**North Somerset Council Planning Department**

**Date: 21/12/23**  
**My Ref: 1782/23/02**

**Site:** Ruslin Farm, Rusling Lane, Butcombe, North Somerset, BS40 7XQ  
**Description:** Application for Variation of a Condition following Grant of Planning Permission  
**Portal Ref:** PP-12691704

Applicant: Mr L Vaughan
Project: Proposed Barn Conversion & Alterations
Address: Ruslin Farm, Butcombe, Bristol BS40 7XQ
Date: December 2023
Drawing No: 2023/B/VAUGHAN/08

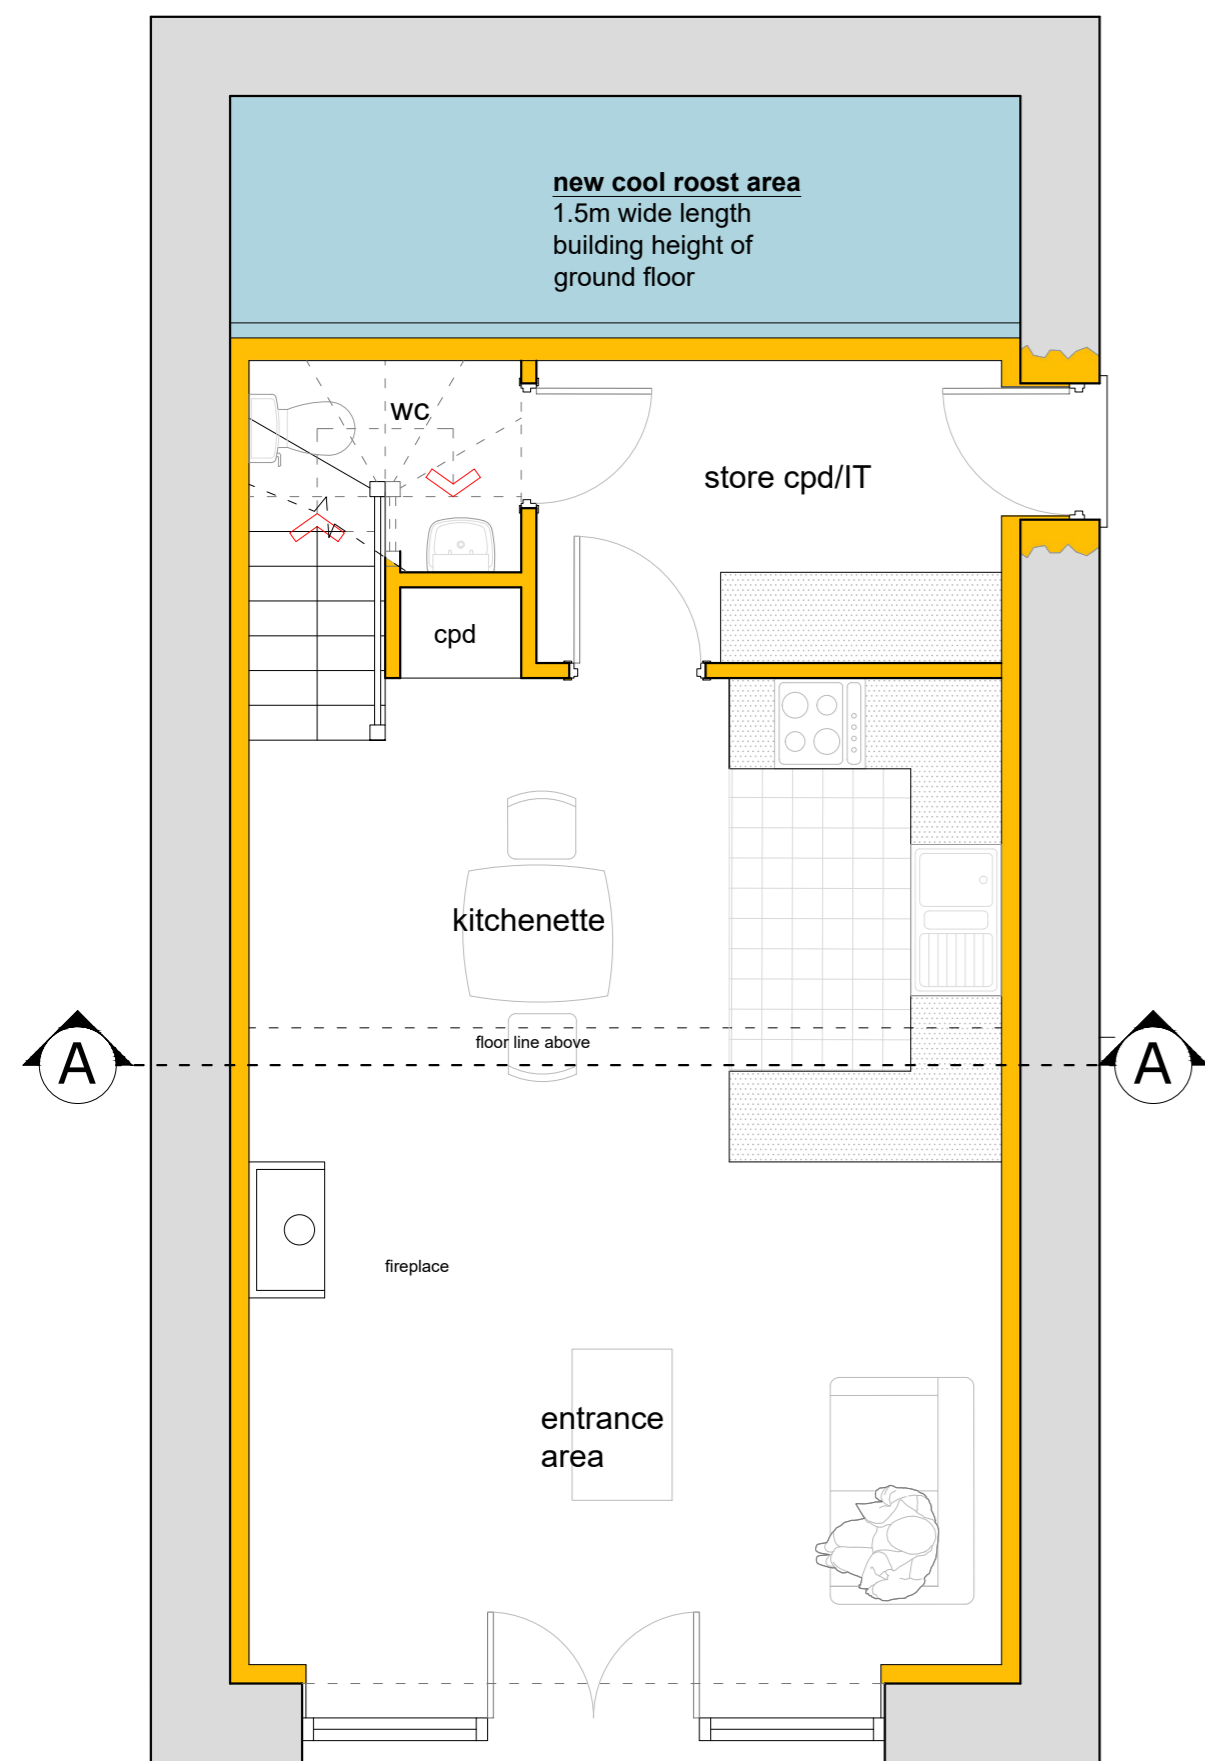
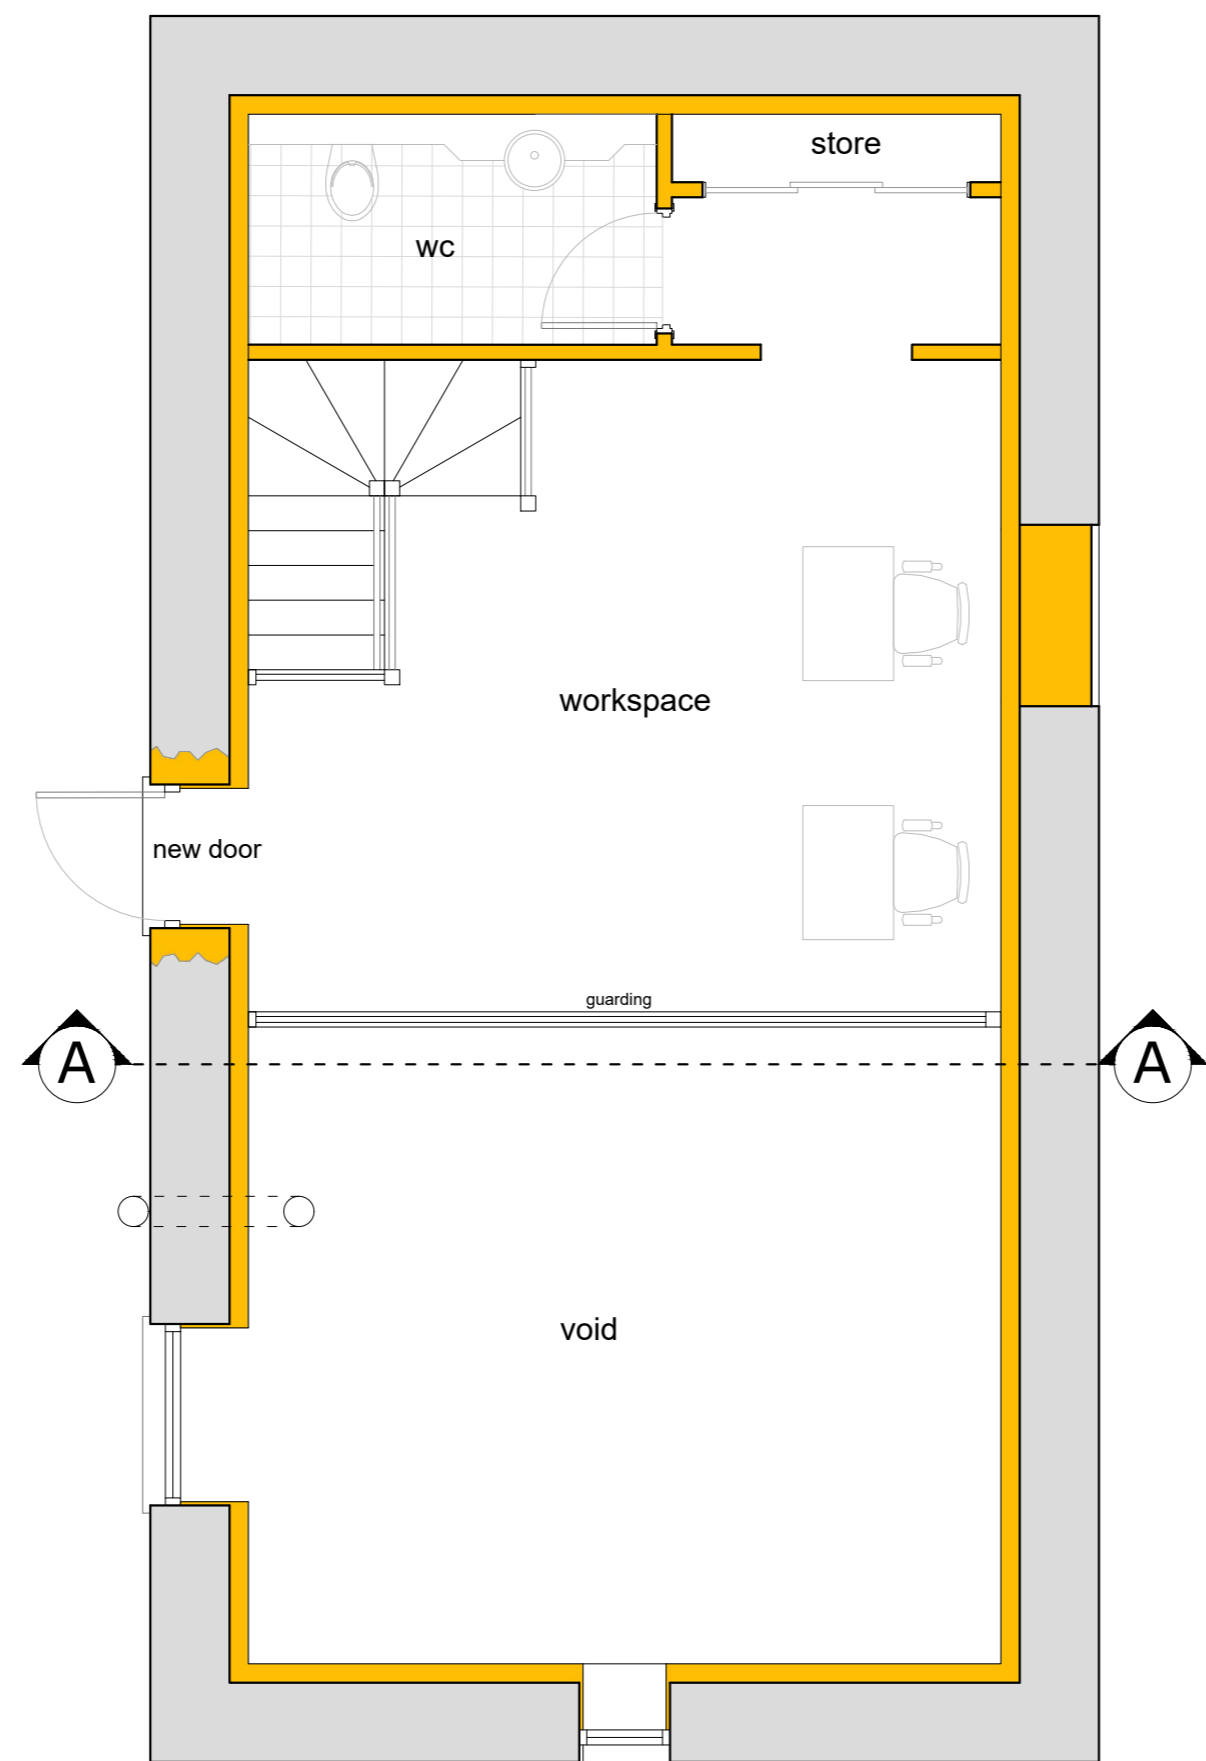
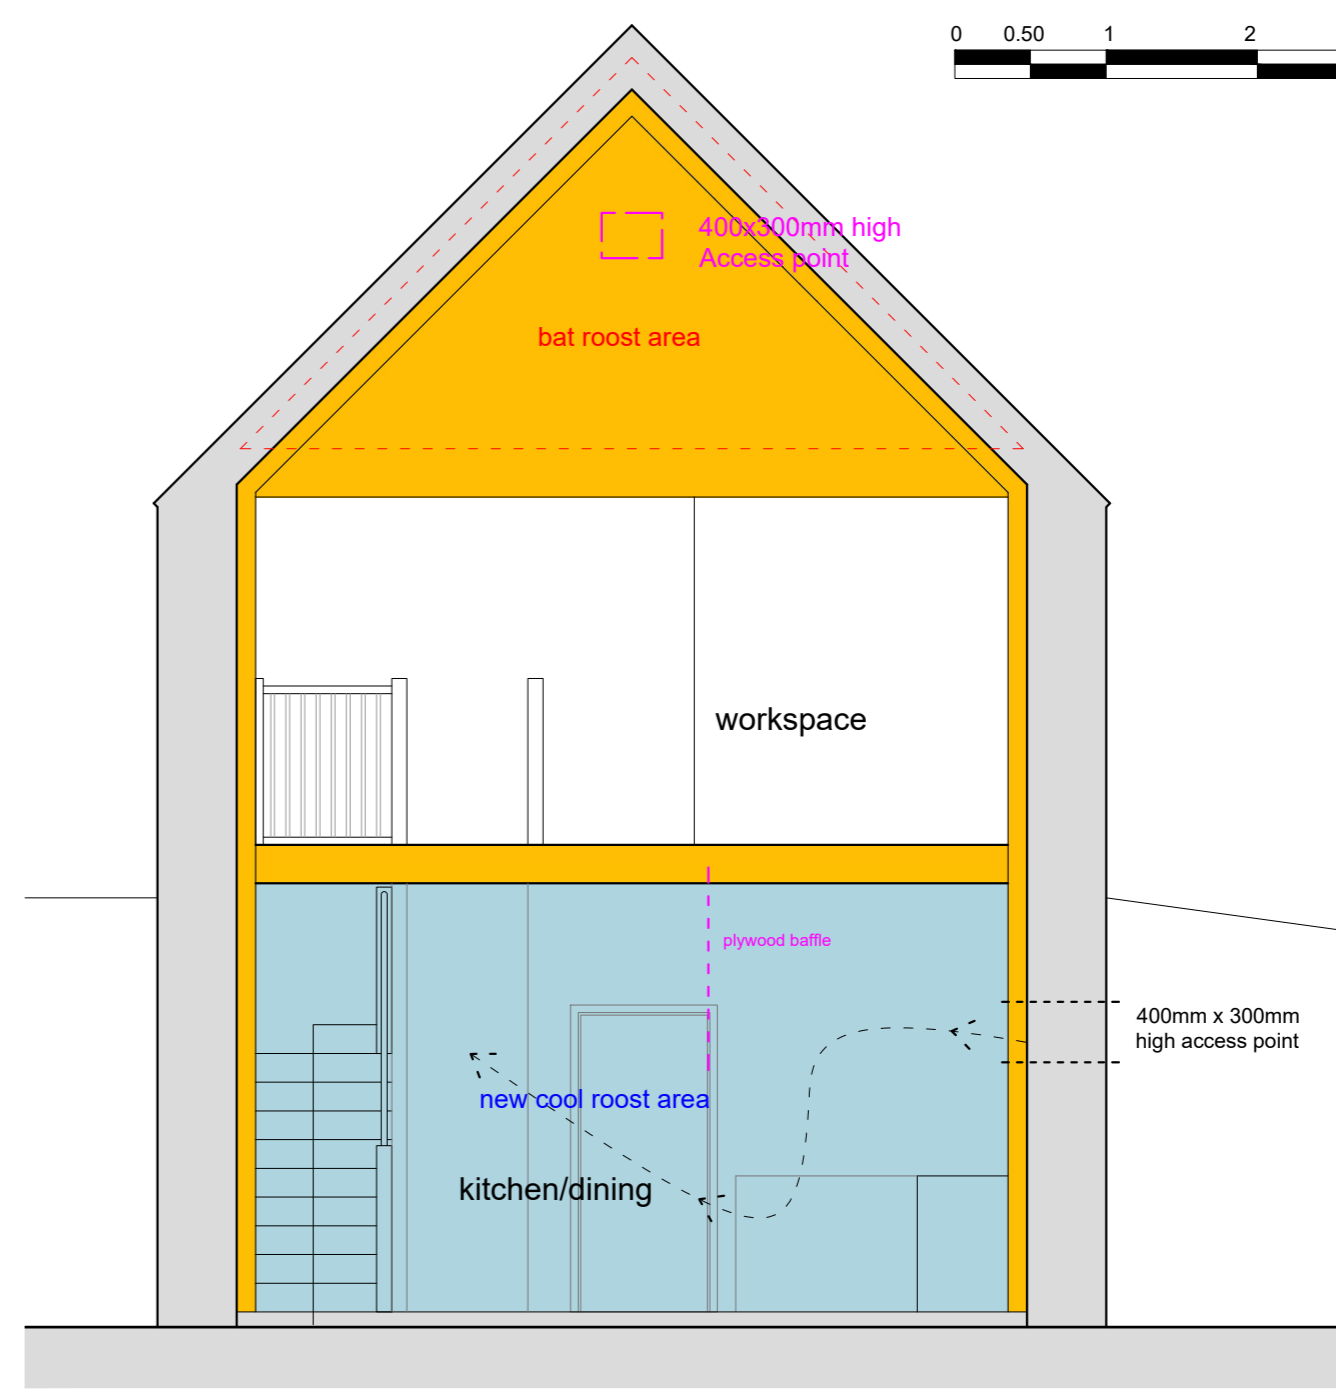
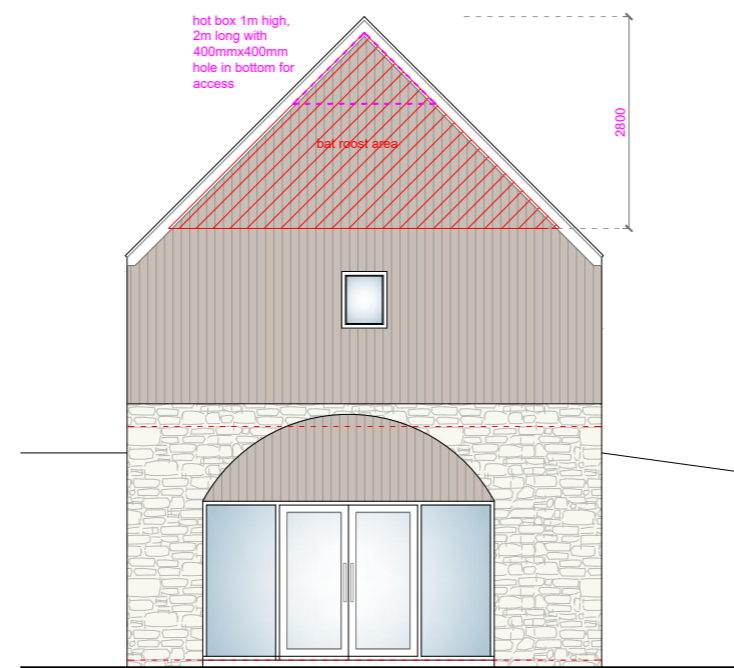
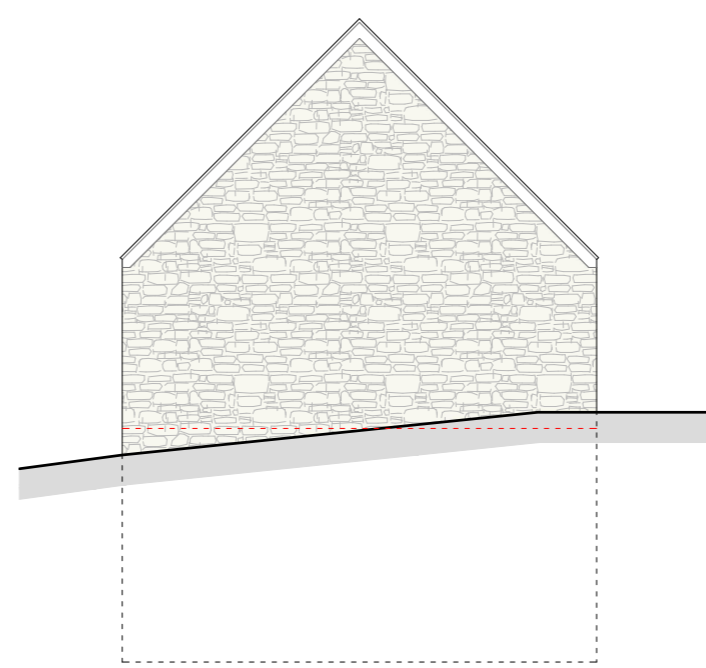
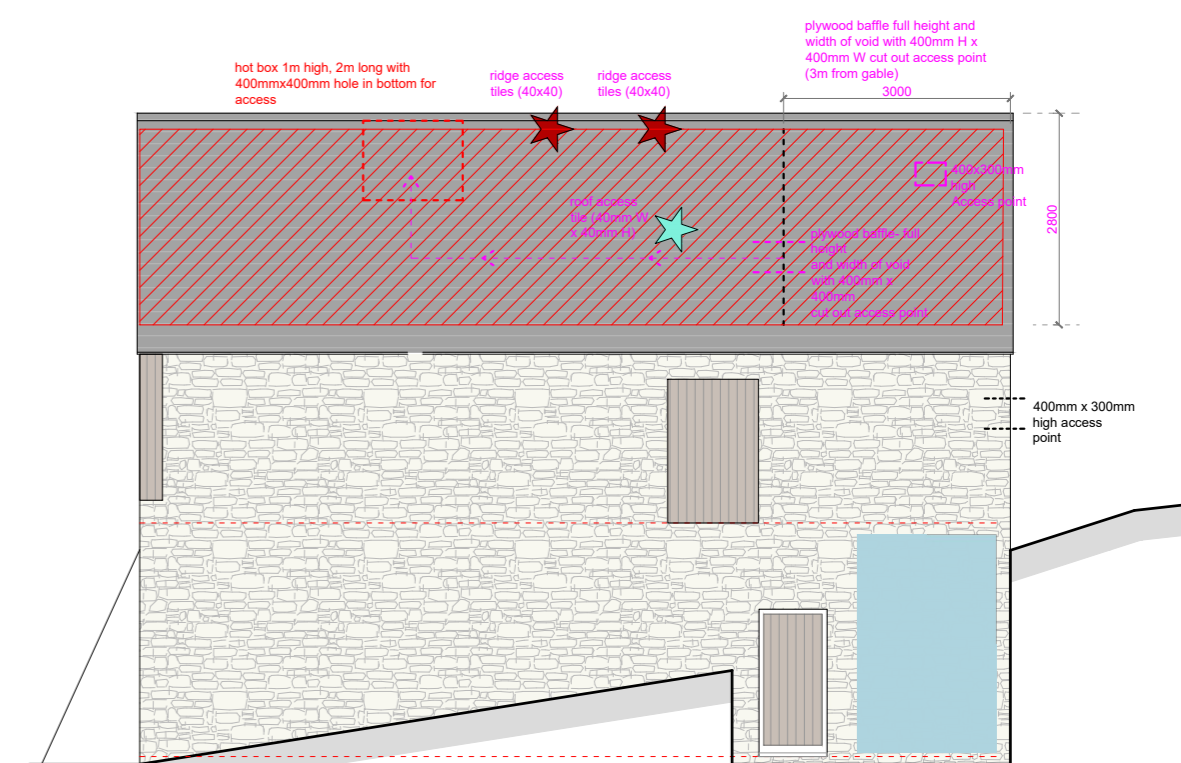
*Drawing no. 2023/B/VAUGHAN/08: Proposed barn conversion & alterations*

The proposed scheme has been amended inline with the updated ecological report/appraisal. This allows for the scheme to include a mezzanine work space. The scheme now also includes a kitchenette and feature log burner. To the west elevation an existing fenestration is utilised and a new door is created.
